## Online Comment

**Application** H13-0292-25  
**Location** Holly Tree House Fengate Moulton Chapel PE12 0XR  
**Proposal** Proposed replacement dwelling

**Name** Gregory Watkinson, Conservation Officer  
**Address** Conservation Officer

Drawing Title:
Car port as proposed

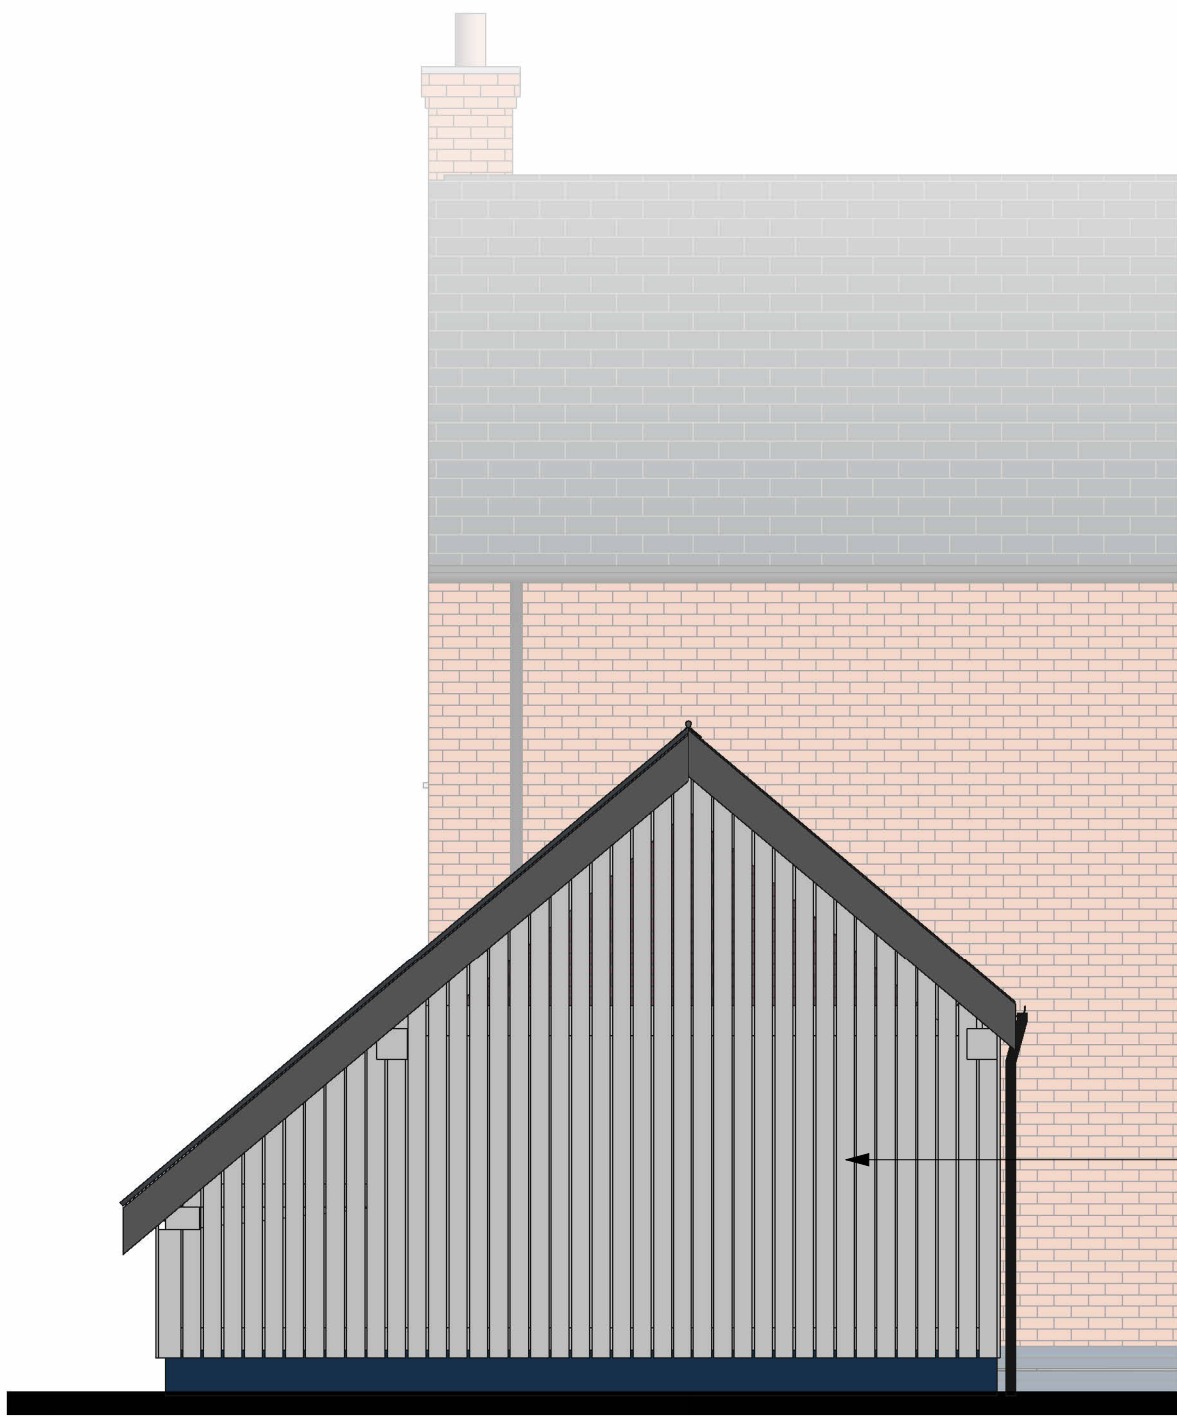
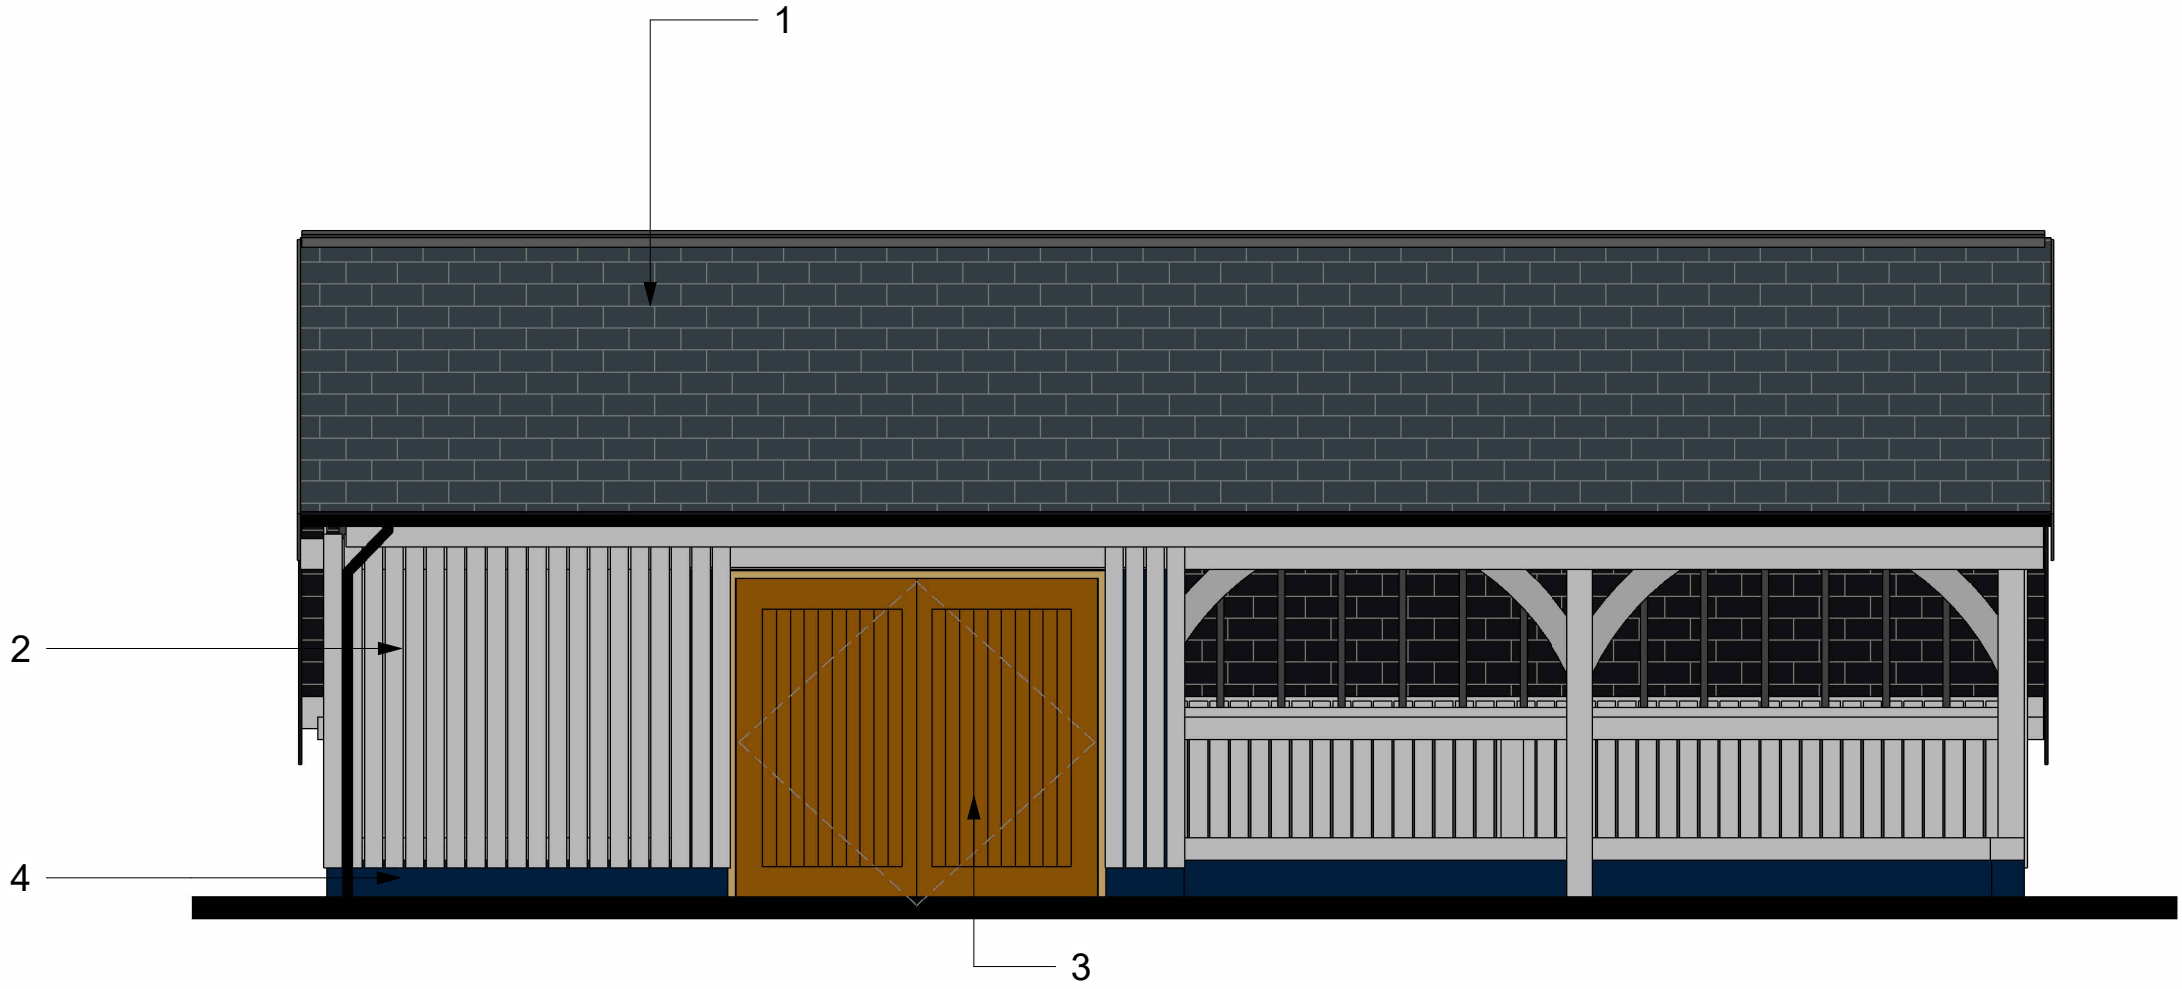
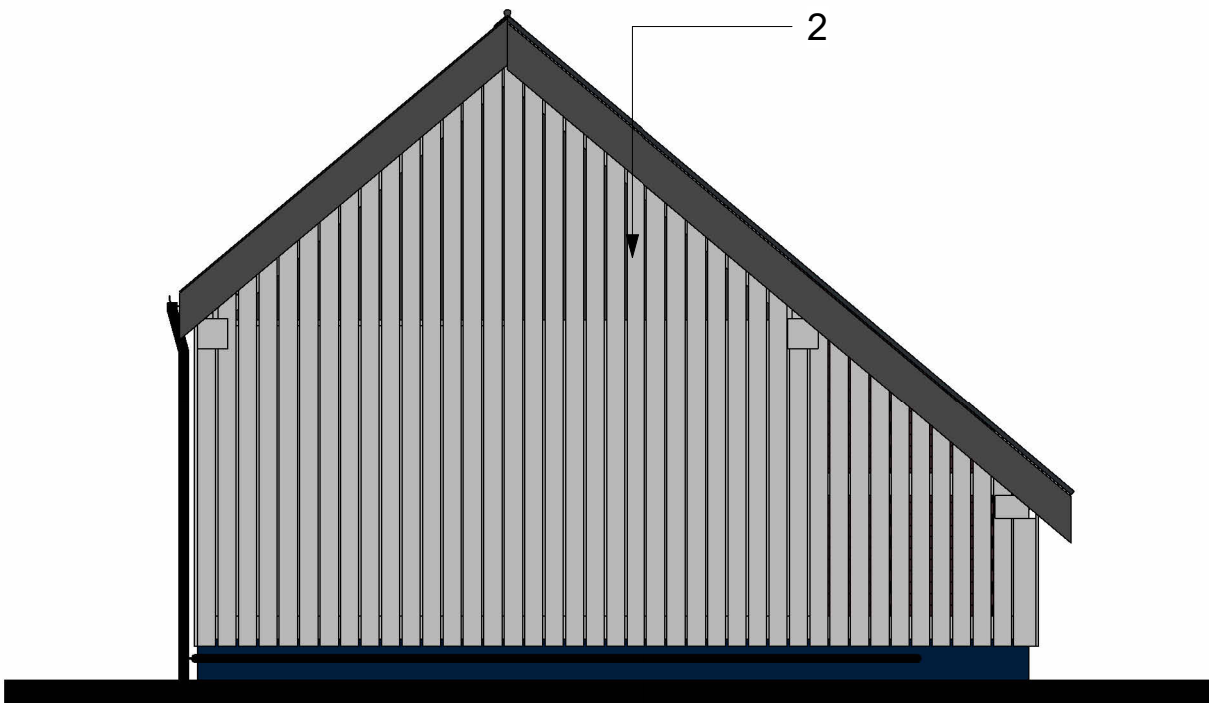
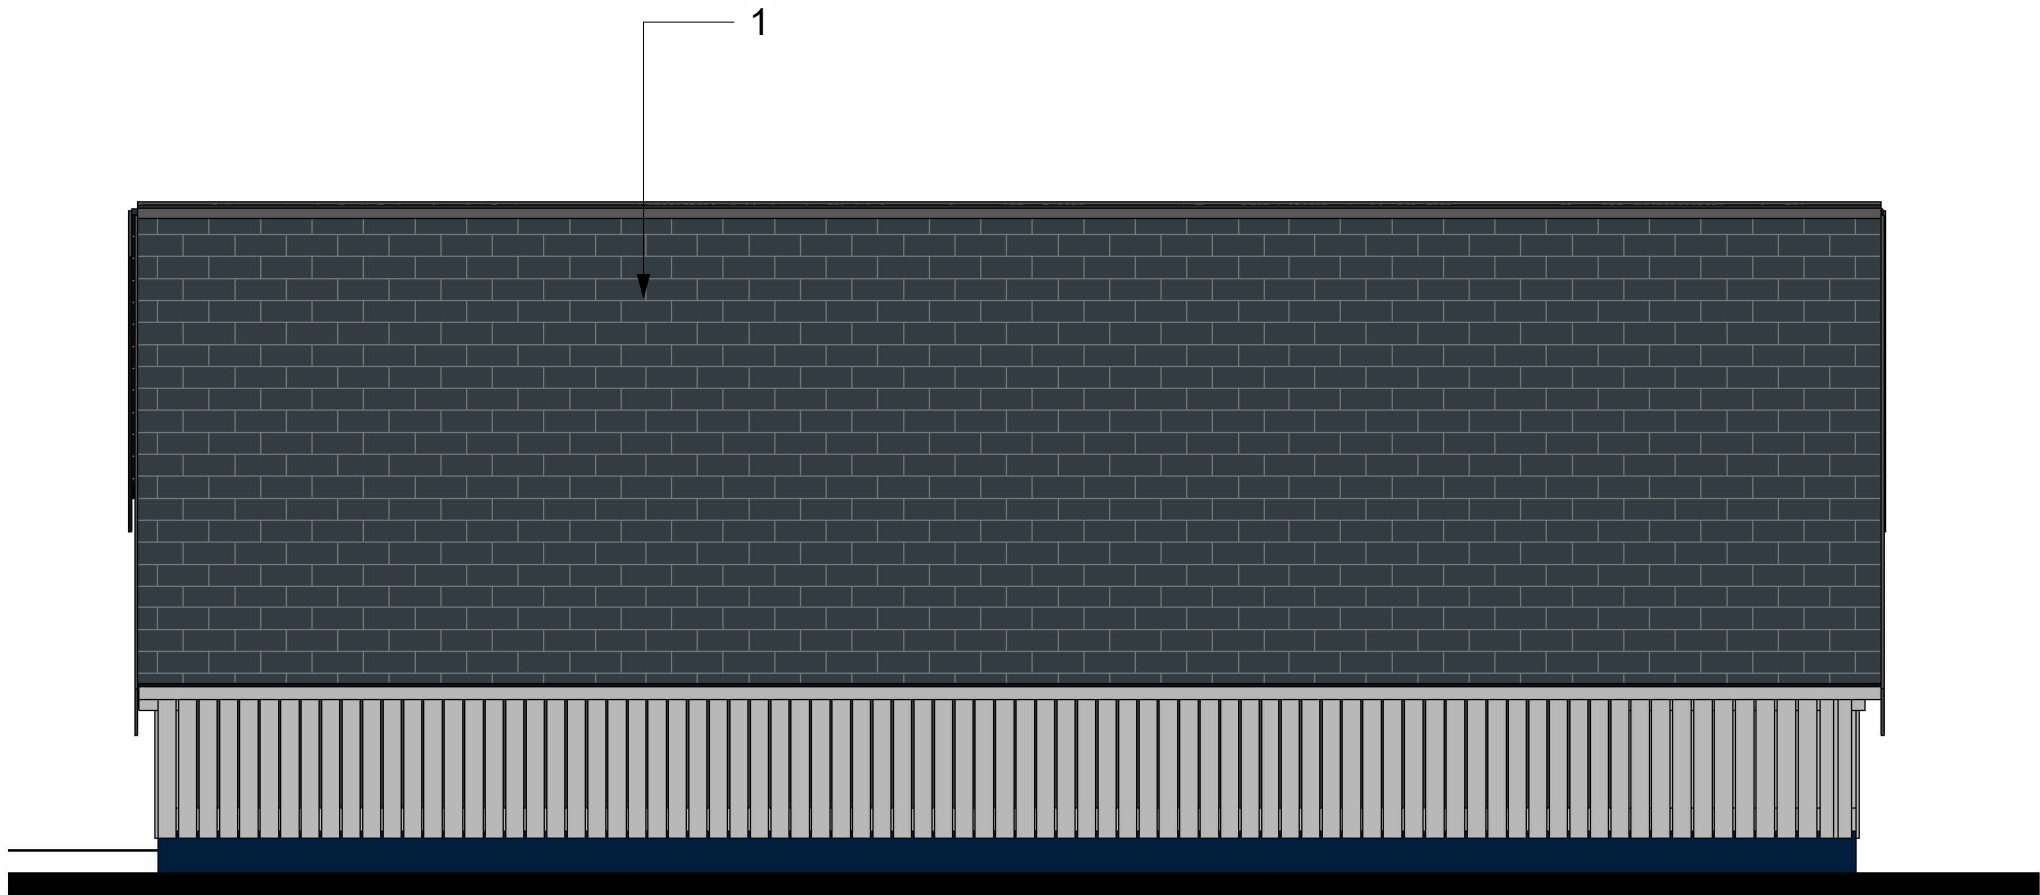
I would, however, request that with an approval, the determination should be made conditional, pending details of external materials, windows, doors and rooflights for both the house and the car port.

Arguably in this case the proposed car port poses a greater influence on the manner in which the adjacent listed building is appreciated as it would directly feature in views of that structure as travelling northbound along Fen Gate. I am satisfied that both the design and scale would not place that at risk. However, it is imperative that control over the final materials and detailing is given to the LPA in this instance.
